Application M/56/15/HH
31 Sea Way, Middleton-On-Sea, West Sussex, PO22 7RZ

We are writing to object to the revised proposals. We welcome the omission of the freestanding garage to the front of property, however we are still of the opinion the remaining proposal are a gross over development of the site which will effect our enjoyment and amenity of our property. The proposals are also clearly contrary to the Middleton on Sea Village Design Statement, specifically the *Future Development Guidelines* which states;

ROOF PLAN
1.100

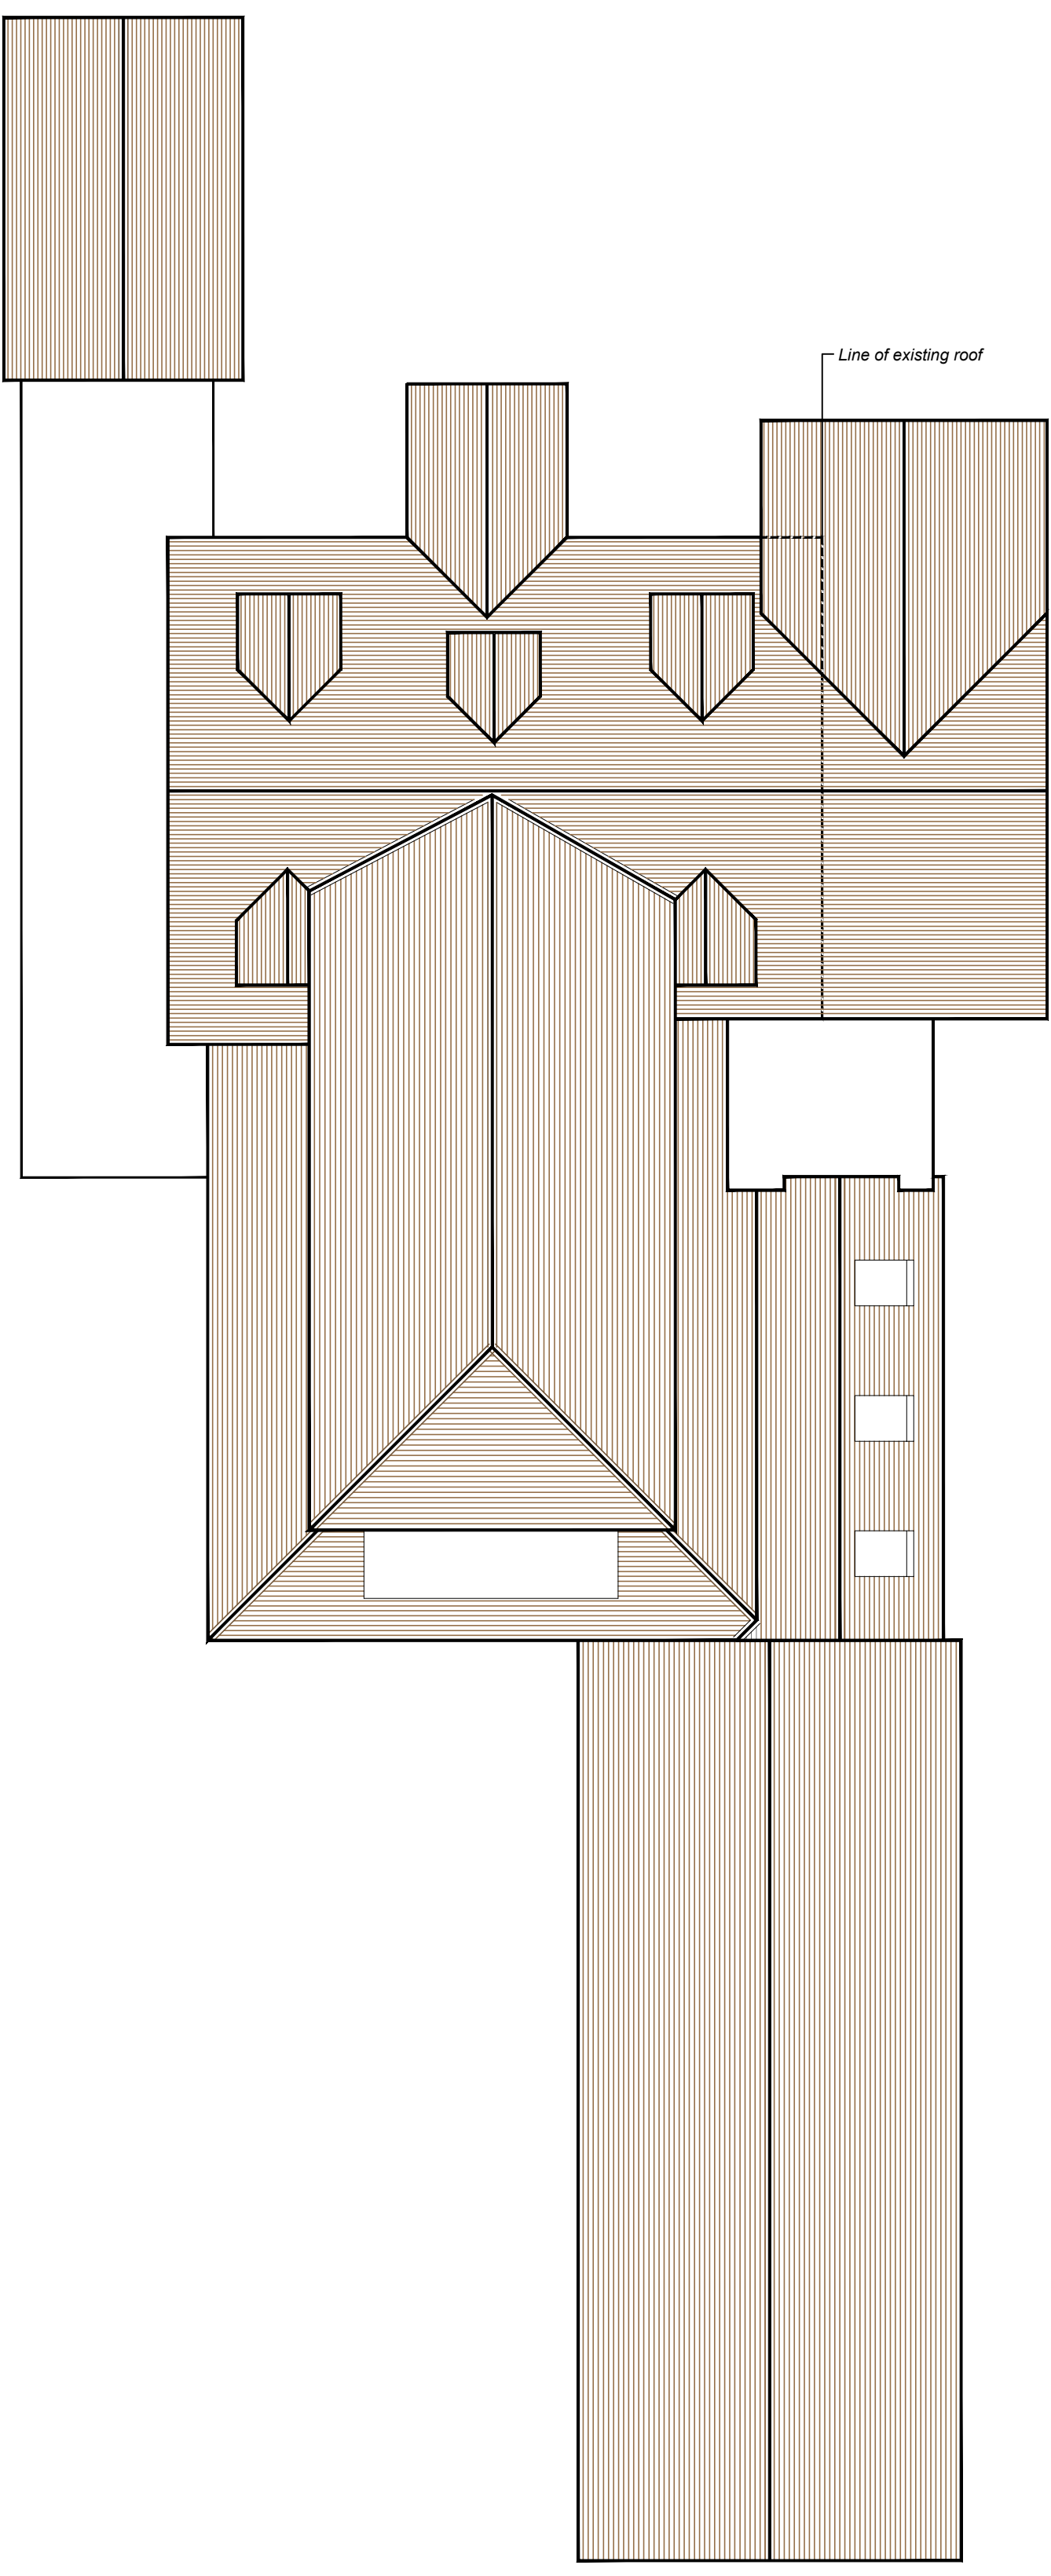
The revised proposal does not change any element of the two storey side extension and our previous objections are unchanged.

Planning applications are to be judged on an individual basis but also viewed against the previous developments on the site and it would appear that No. 31 has been evolving vertically from bungalow to house and now horizontally to fill the site from each neighbour's boundary. This two storey side extension will dominate our house overshadowing our front windows and entrance foyer particularly the evening sunlight.

The 1m side access does not take into consideration the 0.3m overhang of the eaves of the roof creating an overbearing structure right on the boundary. One of the important characters of the Sea Way is the gaps created between properties not just for the enjoyment of residents but for passers-by viewing the built environment from the coastal path. This extension obliterates this gap and forms a property which is developed from its west to east boundary.

There is also the loss of privacy and overlooking from the new first floor dormer window to the 5th bedroom which looks directly down into our front facing window. The loss of light particularly to this window will be dramatic and is against the Middleton on Sea Village Design Statement, *Future Development Guidelines* and should be refused or reduced greatly so as not to affect our amenity. Rights of lights are also a separate issue we will be investigating further.

Surface Water Drain
Sea Way
Middleton-on-Sea

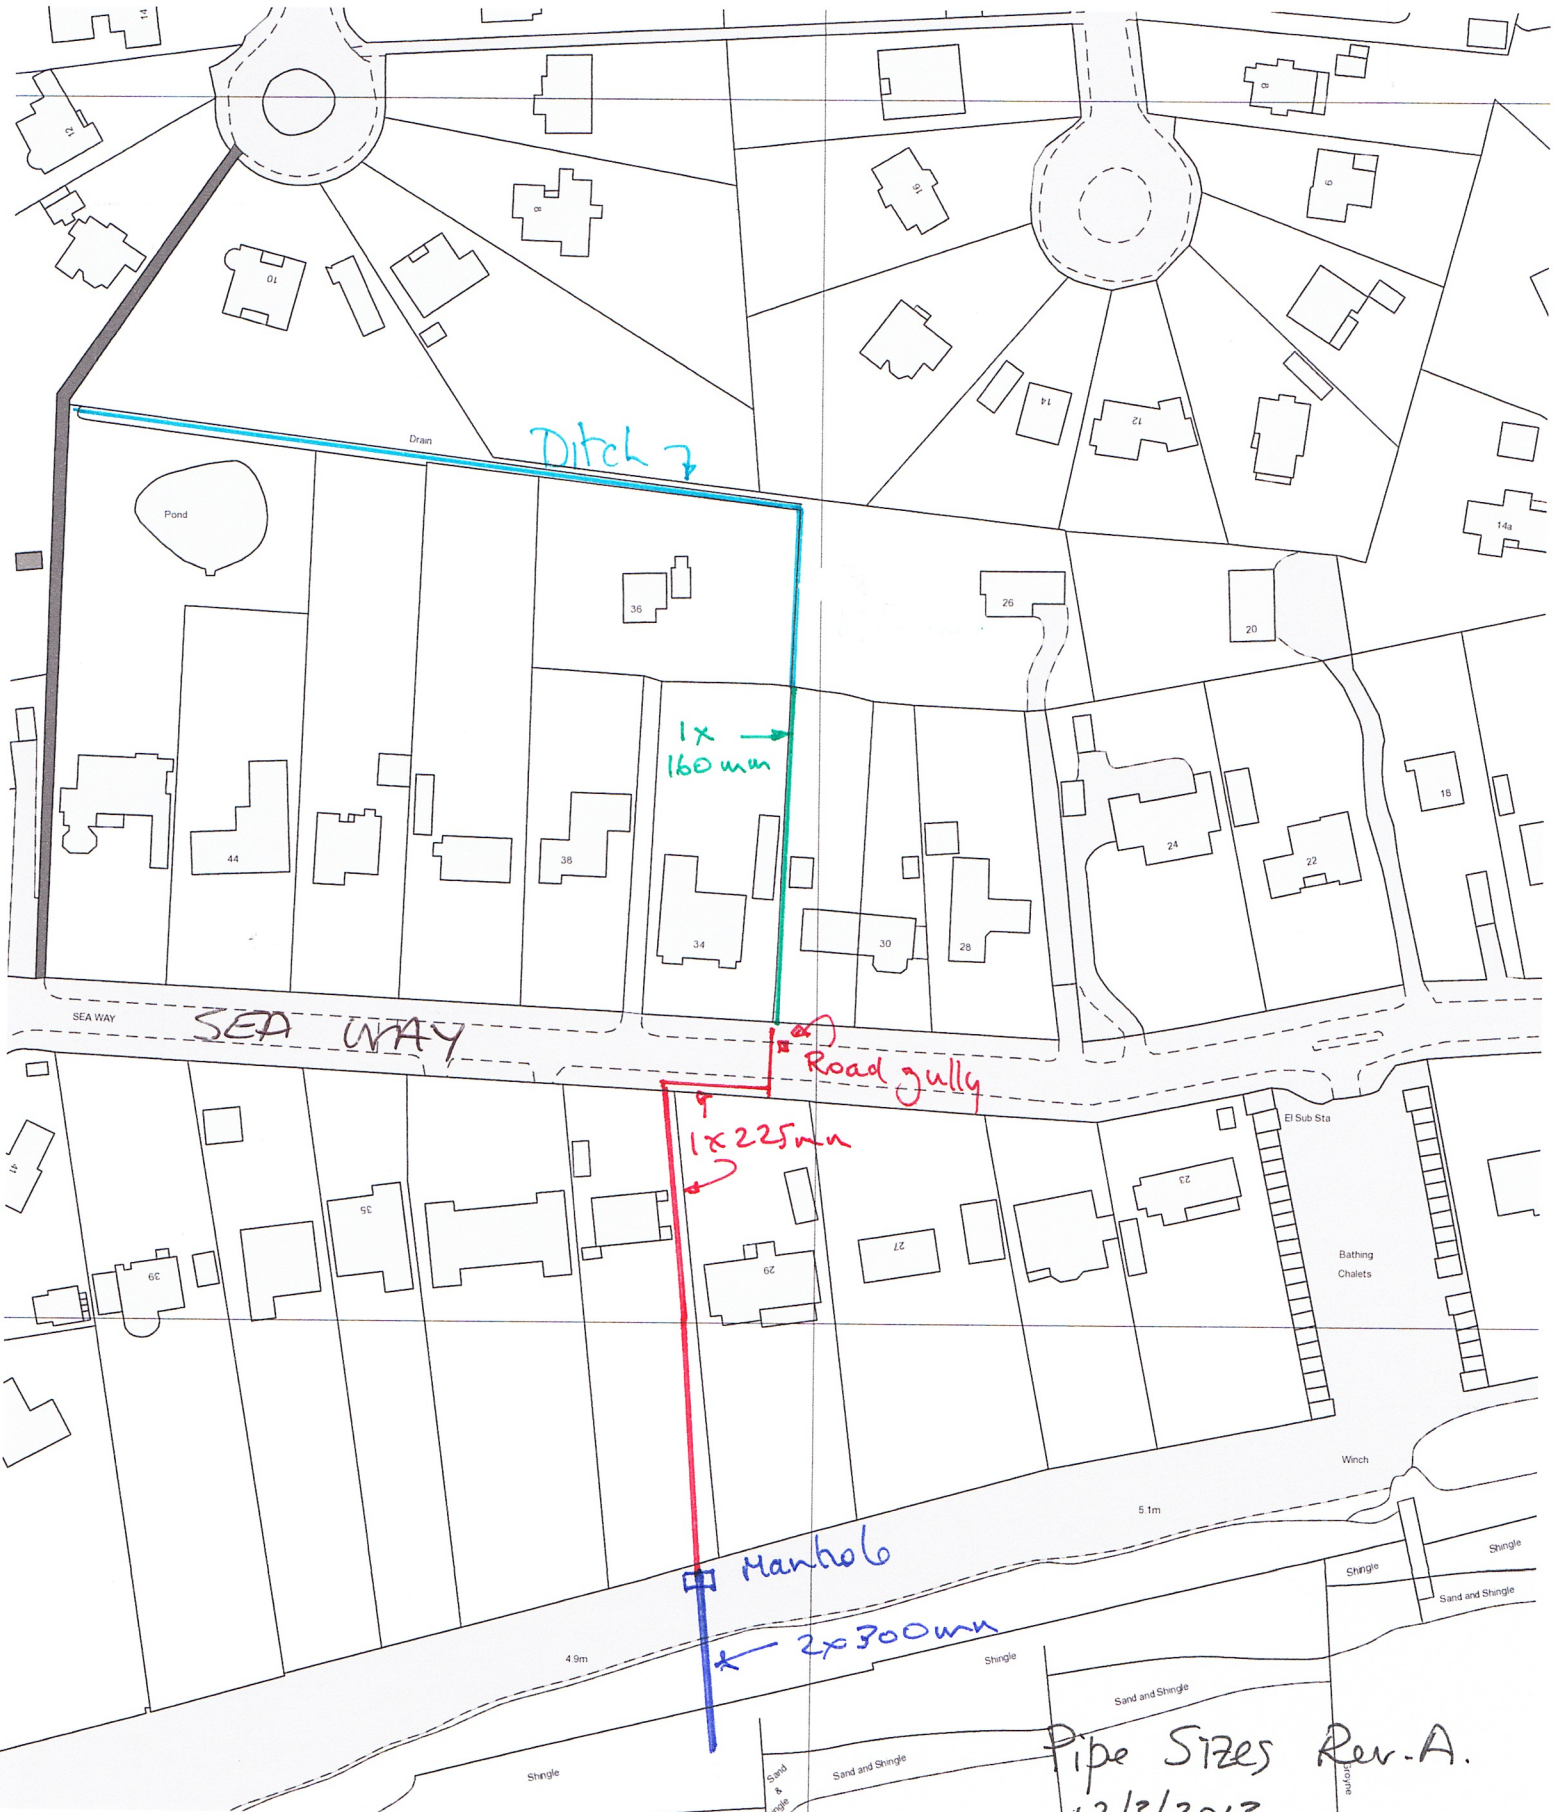
We are aware that national planning policy requires planners to take account of the effects of any development on the potential to cause flooding. It has come to our attention since our original objections that an important surface water drain runs directly along the eastern boundary of No31.

This drain transmits flood waters from areas to the north and Sea Way highway itself and is an important part of the flood alleviation system. The drain run requires maintenance the same as any system and also the ability to upgrade in the future should its capacity prove to be inadequate for future rainfall predictions. The increase in the footprint and loss of garden should also be taken into consideration in the effect run-off.

The proposed extensions do not appear to have taken any account of the drains existence or the requirement to maintain or replace the drain. **From a simple visual**

inspection of the location of the manholes they appear to be approximately 1.5 to 1.75 m from the boundary, which places them directly under the foundations of the extensions. The proposals should therefore be refused or greatly reduced to allow working area provision for maintenance or replacement of the drain.
